From: [REDACTED] **On Behalf Of** CCD Planning Consultations
Sent: 08 June 2018 11:34
To: Planning.Responses
Cc: Derek Whittington
Subject: RE: Planning Consultation on: WA/38/18/HH

TO:	Arun District Council FAO: Andrew Wood
FROM:	Highways, WSCC
DATE:	8 th June 2018
LOCATION:	Longacres, Eastergate Lane, Walberton, BN18 0BA
SUBJECT:	WA/38/18/HH new vehicular access with parking & turning.
RECOMMENDATION:	ADVICE
S106 CONTRIBUTION TOTAL:	£N/A

Drawing Title
LAYOUT PLAN

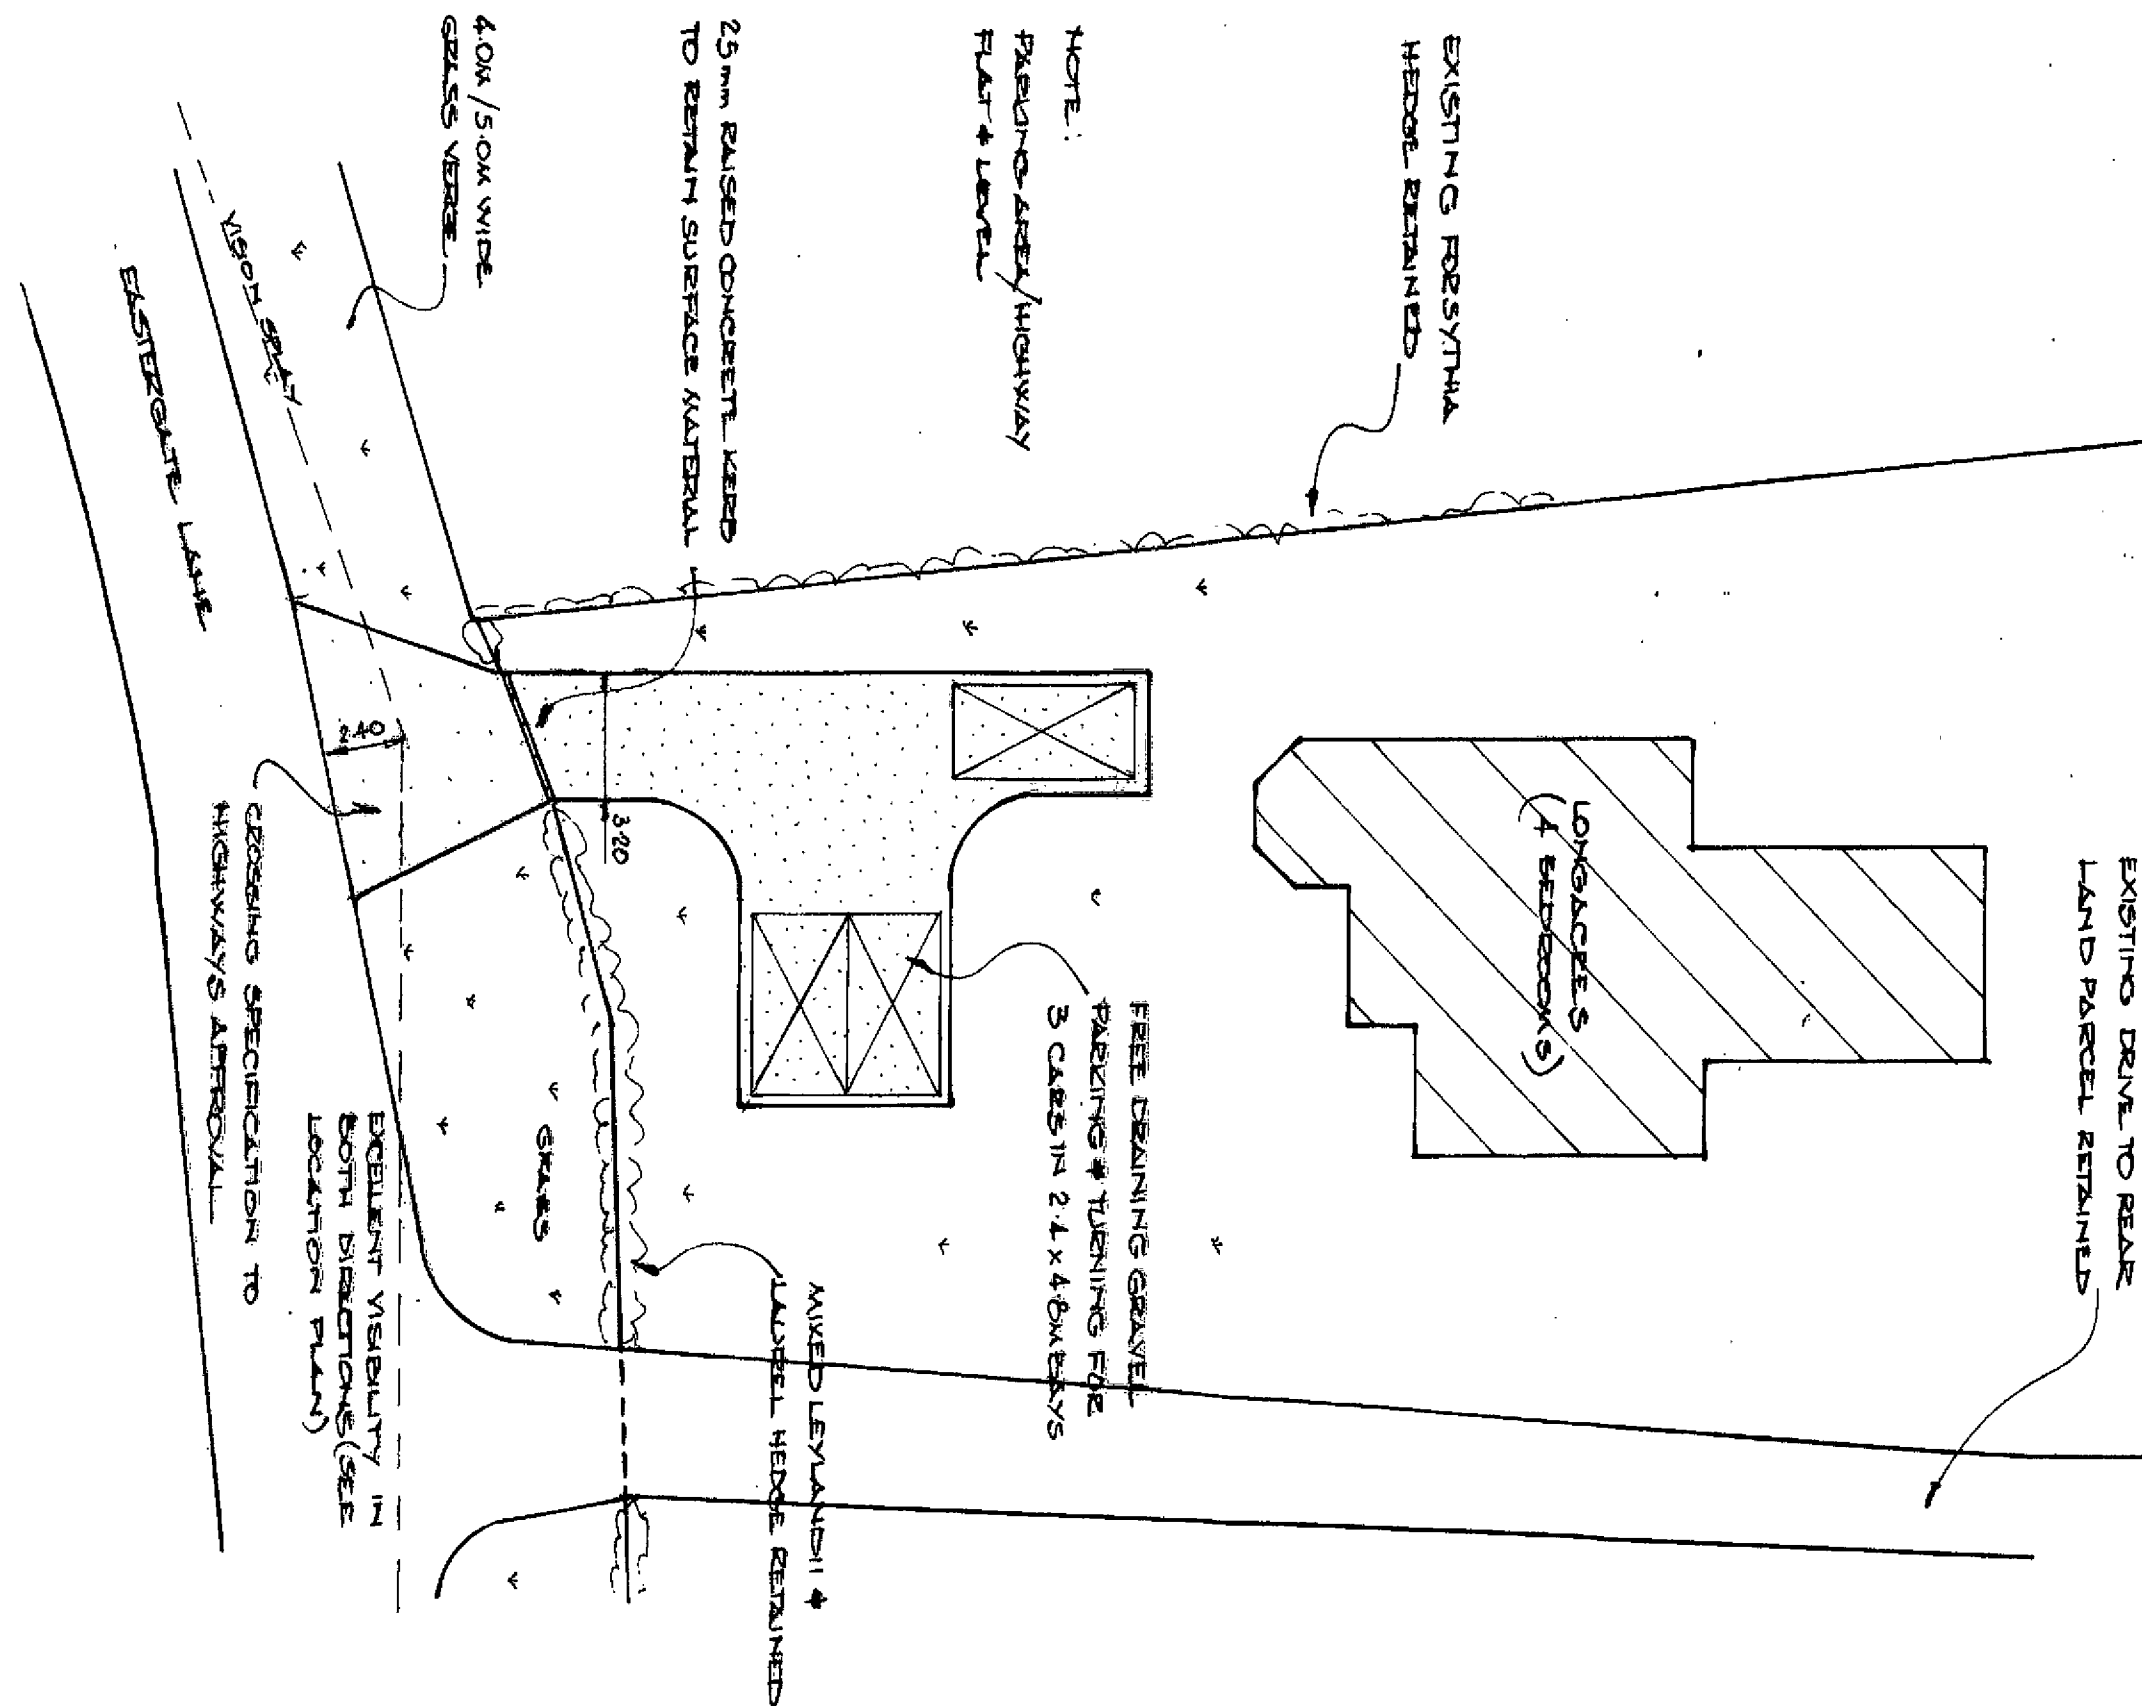
Eastergate Lane is 'C' classified rural highway subject to 40 mph speed restriction in this location. The proposals are for new vehicle crossover to serve the existing dwelling 'Long Acres' (which currently appears to share vehicle access with neighbouring property). A car parking area for 3 x cars and turning is also proposed.

From an inspection of the proposed plans the parking spaces meet the required 2.4m by 4.8m and sufficient space is available on site for turning so that a car can exit on to the public highway in a forward gear.
